5 December 2019

Re: Application Number SSD-9494, New Public School, Estella Road, Wagga Wagga

Figure 24 Building arrangement plan

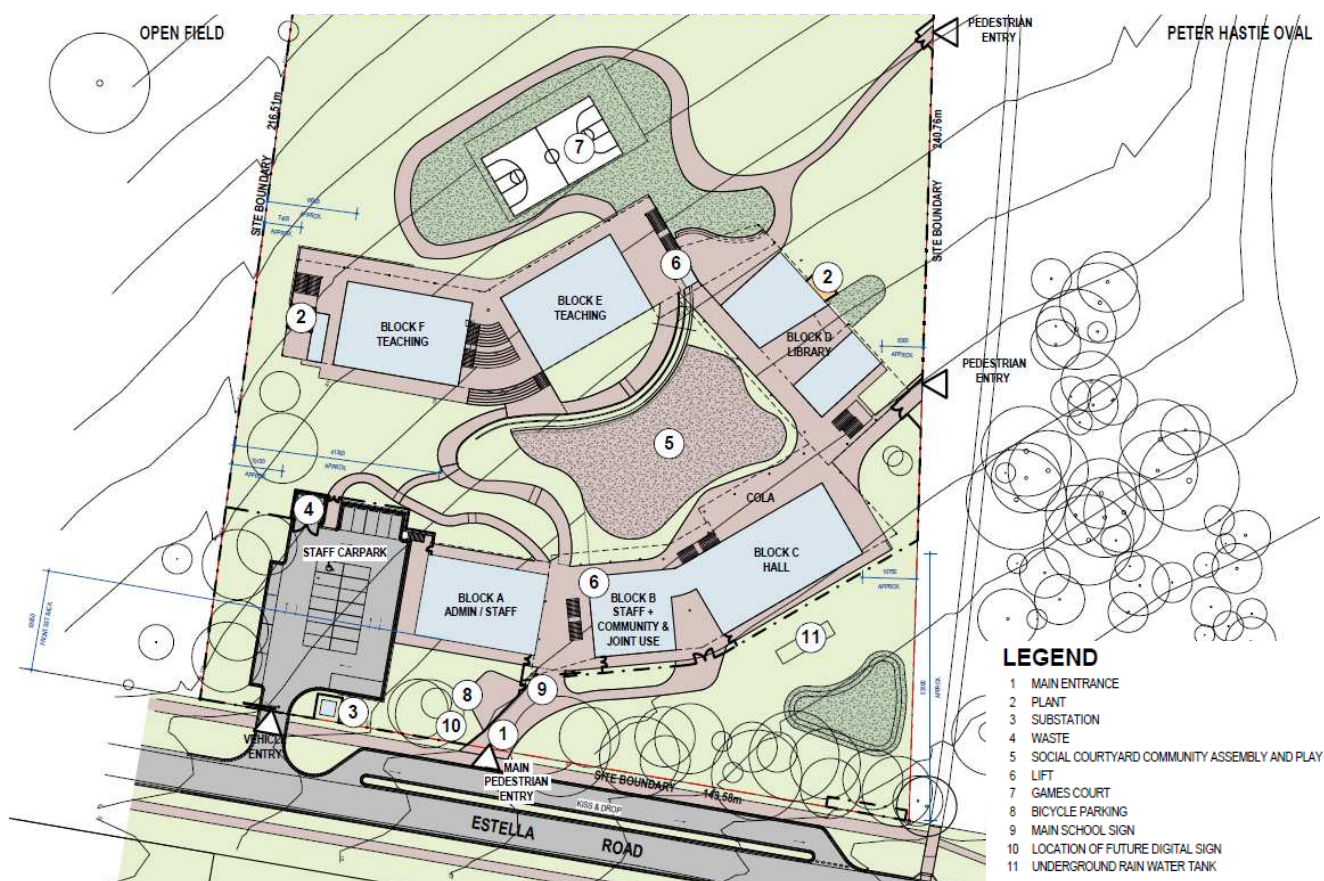
We note the provision of vehicle access between Blocks C and D on the Landscape Plan. Other plans note this as a pedestrian entry. The bitumen path in that location was constructed for pedestrian access and is not considered suitable or appropriate for vehicular access. We trust that this inconsistency will be rectified and that all vehicular access to the site will be via the internal car parking area.
